City of Albuquerque Stormwater Construction Site Inspection Report

ESC File No.	M15E023B	Project Name:	Avid Hotel		
NPDES Id. No.	NMR1006J0 & 6IR	Location:	1441 Woodward Rd. SE		
6/30/2024	Owner	Contractor			
Operator	1441 Sunport, LLC		HEI Construction, LLC		
Contact name & title	Yogash Kumar & R-Nicholas Eveleigh				
e-mail	heiconstruction@yahoo.com & rne@hmsgallup.com				
Contact Phone #	879-7168		879-7613		
COA Inspector	Doug Hughes		Start/End Time:	8:30am	
Construction Phase:	Paved, near closeout				
Type of Inspection:	Regular	Storm Event	Past Storm Event >0.25"	311/Complaint	Follow Up
Weather at time of inspection?			clear	Temperature: ~	80
Estimated date of last storm 0.25" or greater			6/29/2024

SILT FENCE

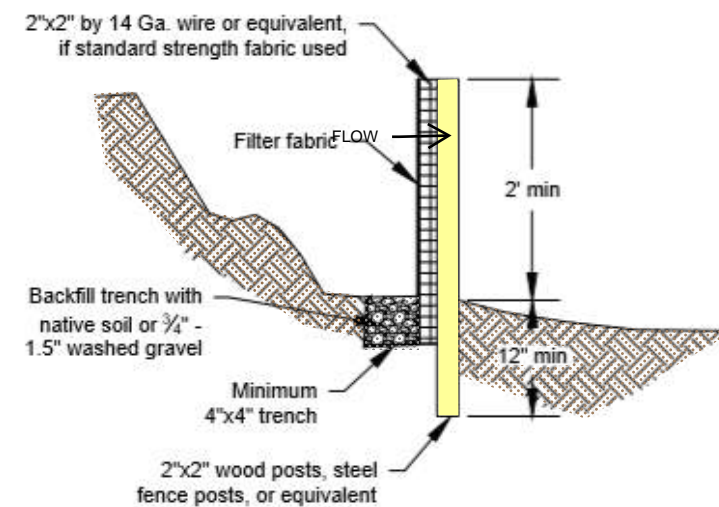
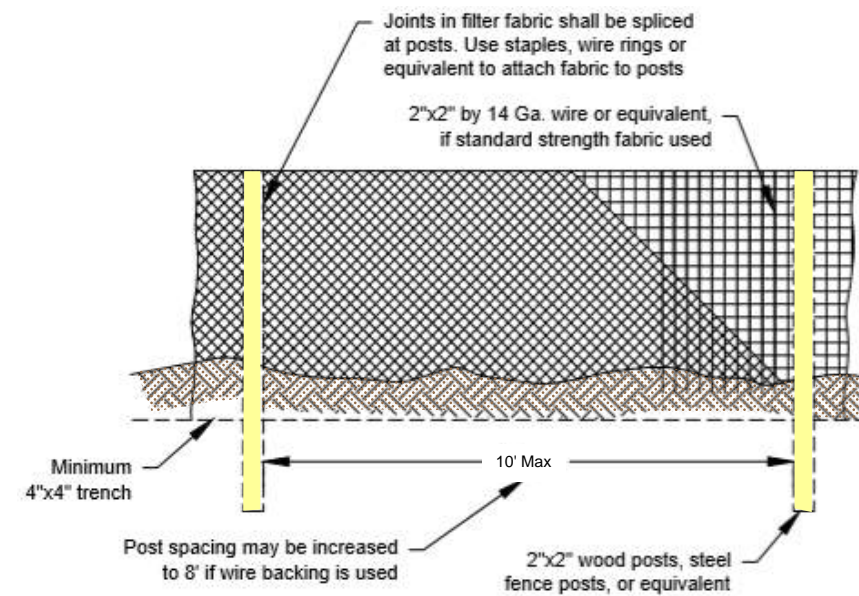
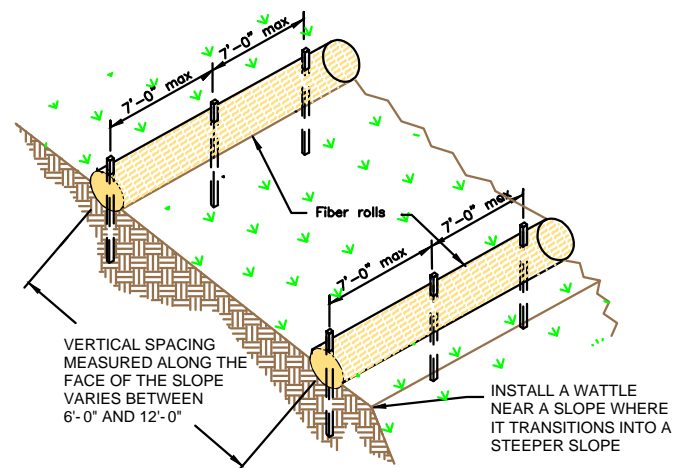
Item Number	Deficiency/ Corrective Action				
1	BMPs —The silt fence in the NW corner of the site failed because it was not designed and installed according to good engineering practices, in violation of CGP 2.1.2. It receives concentrated flow because it isn't installed on contour. Required mitigation: Redesign and reinstall the stormwater controls in the NW corner of the site in accordance with good engineering practices, including applicable design specifications.				
2	Sediment - Stormwater from this site caused severe erosion on this site and downstream, resulting in a significant portion of the sediment deposition at the bottom of the hill in Flightway Ave. Required Mitigation: Where sediment has been discharged from your site onto paved roads and sidewalks, remove the deposited sediment by the end of the same business day. Remove the sediment by sweeping, shoveling, or vacuuming these surfaces or using other similarly effective means of sediment removal. You are prohibited from hosing or sweeping tracked-out per CGP 2.2.4.d
